**Our Ref** CRTR-PLAN-2017-23503  
**Your Ref** 2017/93396

**Proposal:** Demolition of existing industrial buildings and erection of 18 apartments with associated landscaping works to form vehicular parking, cycle parking and refuse storage areas (within a Conservation Area).

**Location:** Vale Works, 25 Morley Lane, Huddersfield

**Waterway:** Huddersfield Narrow Canal

**DRAWING TITLE:** PROPOSED DRAWINGS  
SITE LAYOUT PLAN

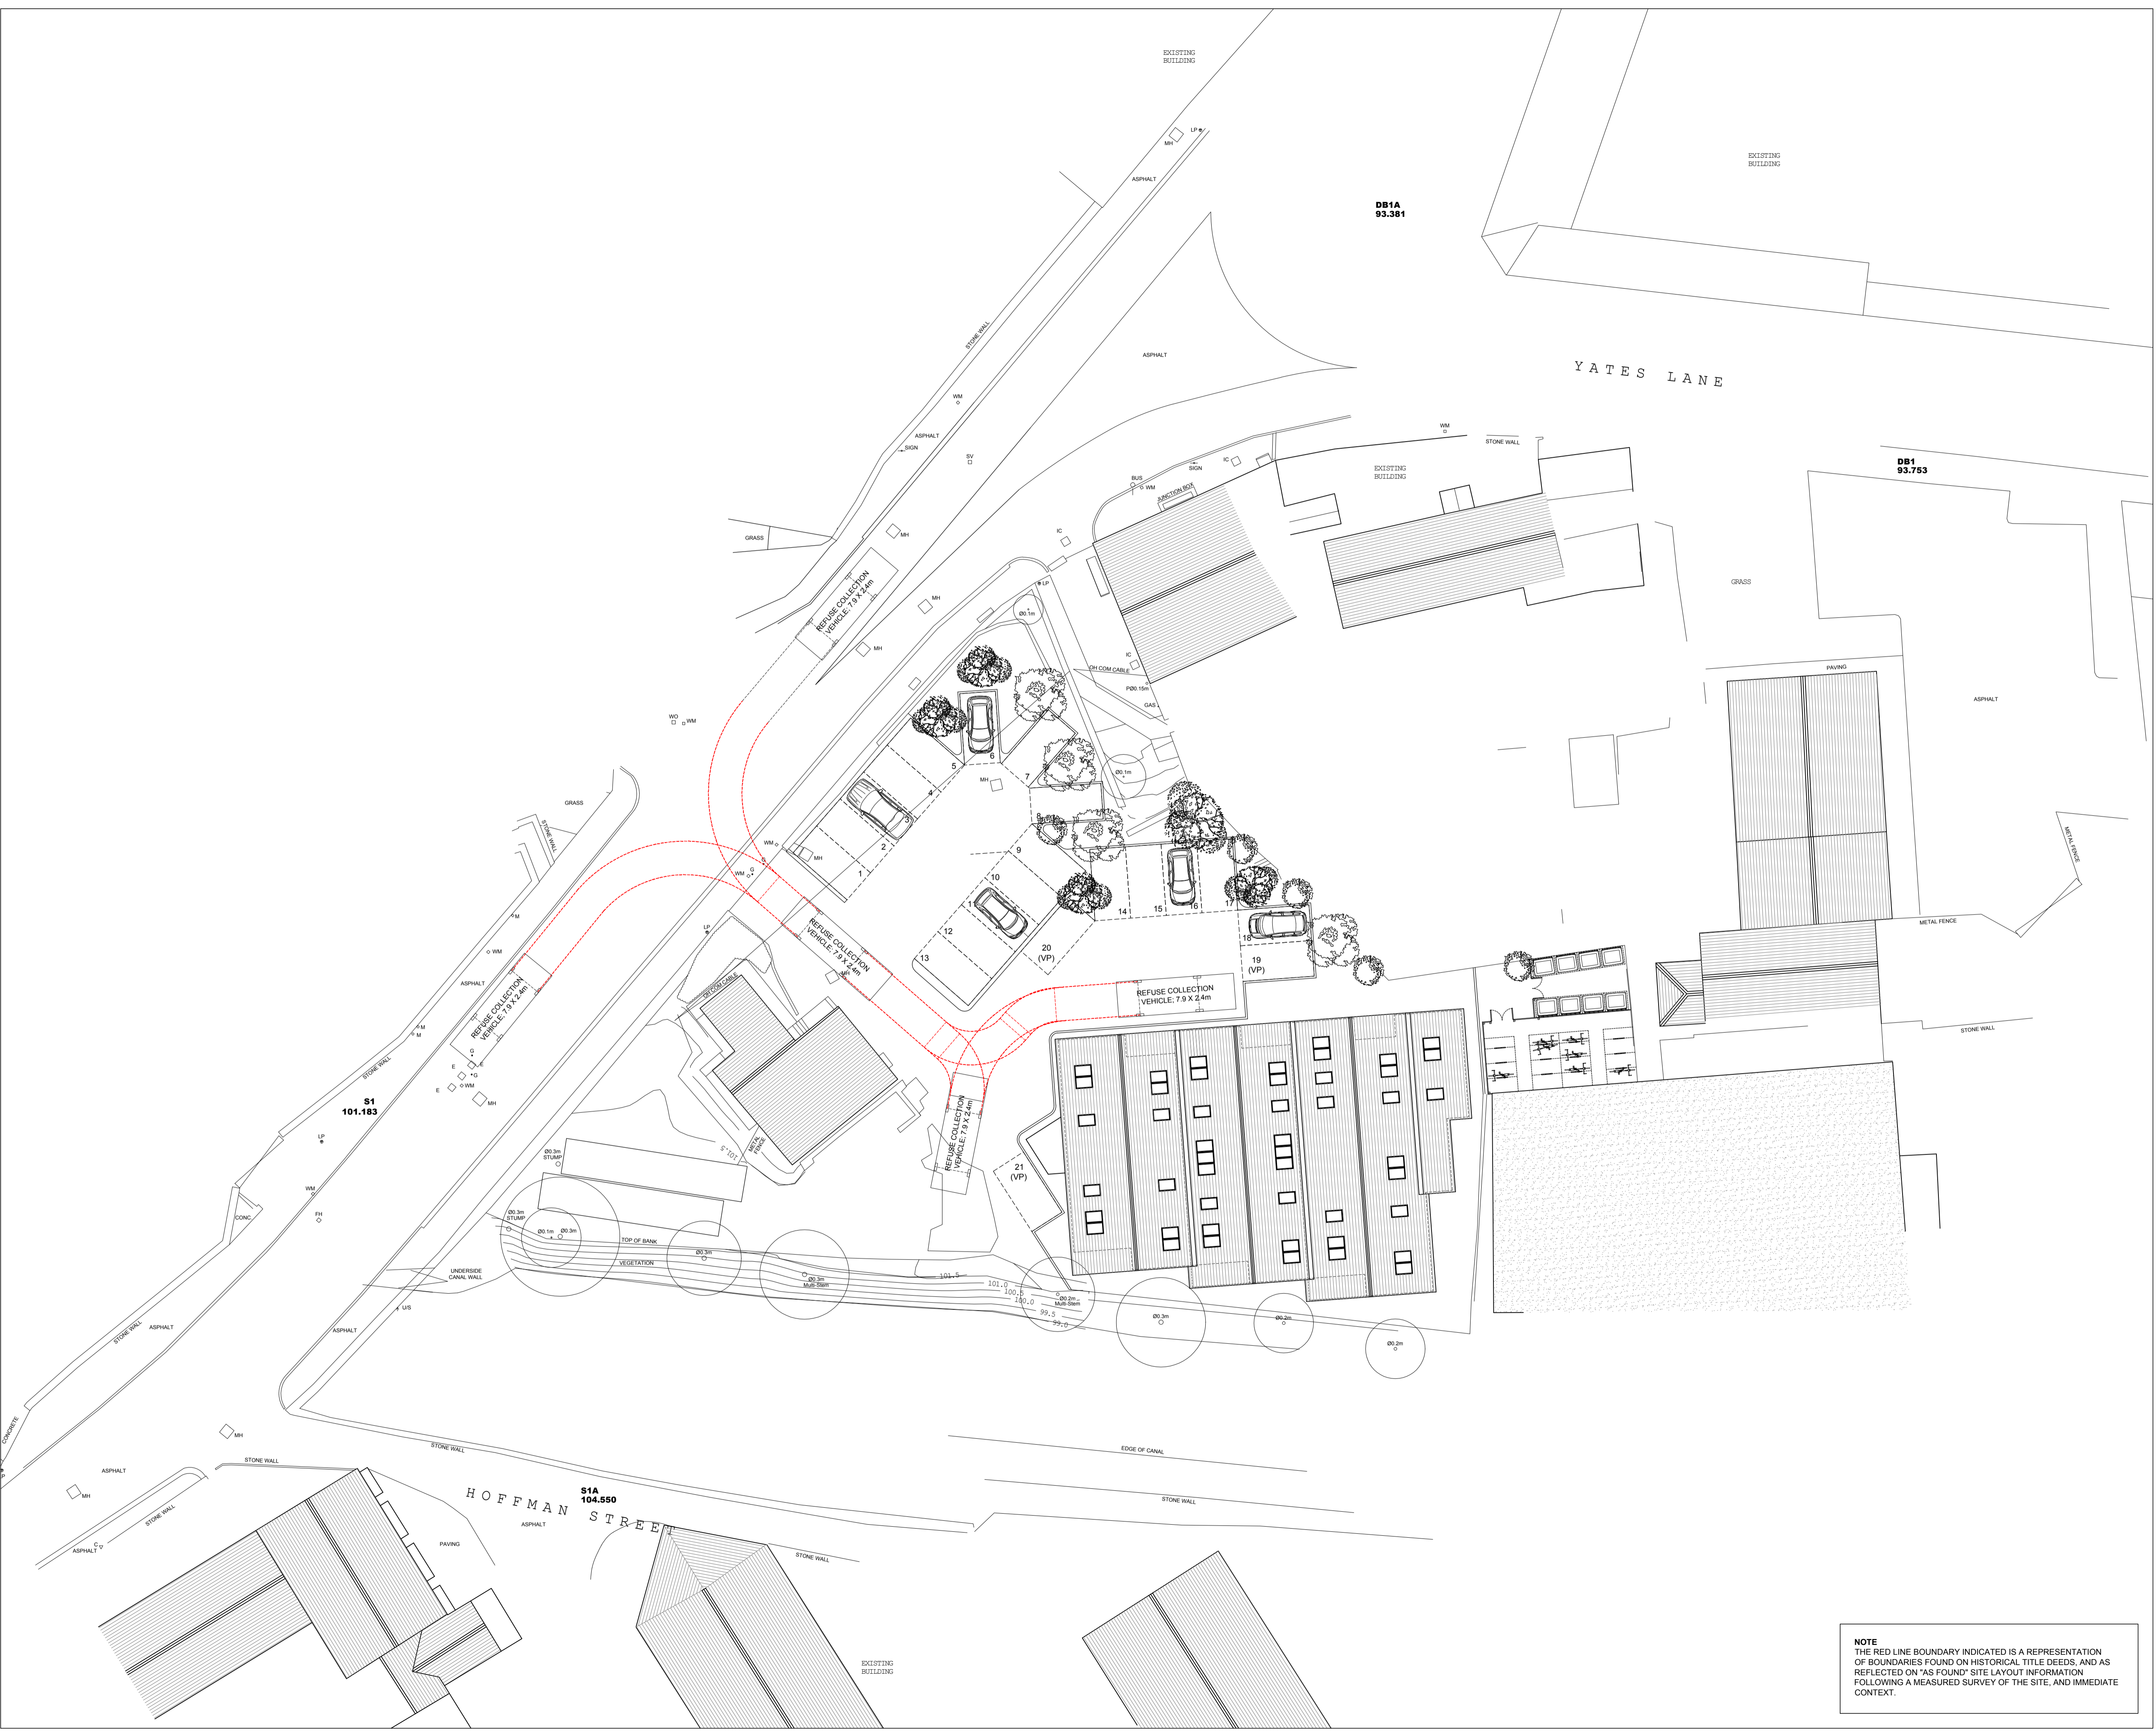
The proposed new building would be situated upon the top of a cutting next to the Huddersfield Narrow Canal. The proposed development has the potential to impose additional loading onto the cutting and the canal wash wall below, and there is a need to ensure that the development

will not result in an increased risk of slope failure into the canal. It is essential that structural integrity is not put at risk as part of any development proposal, including excavations for foundations or vibrations from plant or machinery.

We therefore request that, prior to the commencement of development, details including loading calculations should be provided to demonstrate that the development will not result in a loss of slope ground stability, or any additional loading upon the canal wash wall below.

In the case of this site, we request that consideration to ecology is made alongside any landscaping plan as it is developed for the site. We request that a landscaping scheme and management plan are provided in order to secure net benefits (alongside native planting) to safeguard and strengthen the adjacent Green Corridor. This could be secured by condition.

In addition to the above, lighting alongside the canal has the potential to disturb protected species, notably bats, which commonly utilise our network. We therefore request that lighting upon the canal-side of the building is controlled in order to limit the potential for light pollution exposure towards the canal.

***Prior to the commencement of development, information shall be provided to and approved by the Local Planning Authority to demonstrate that the development will not result in additional loading onto the canal cutting or wash walls that would harm the structural integrity of the waterway infrastructure. Thereafter, development shall be carried out in accordance with the approved details. Details should include calculations to demonstrate that additional loads from the foundations of the development will not harm the slope stability of the cutting, or result in additional loading upon the wash wall of the canal.***
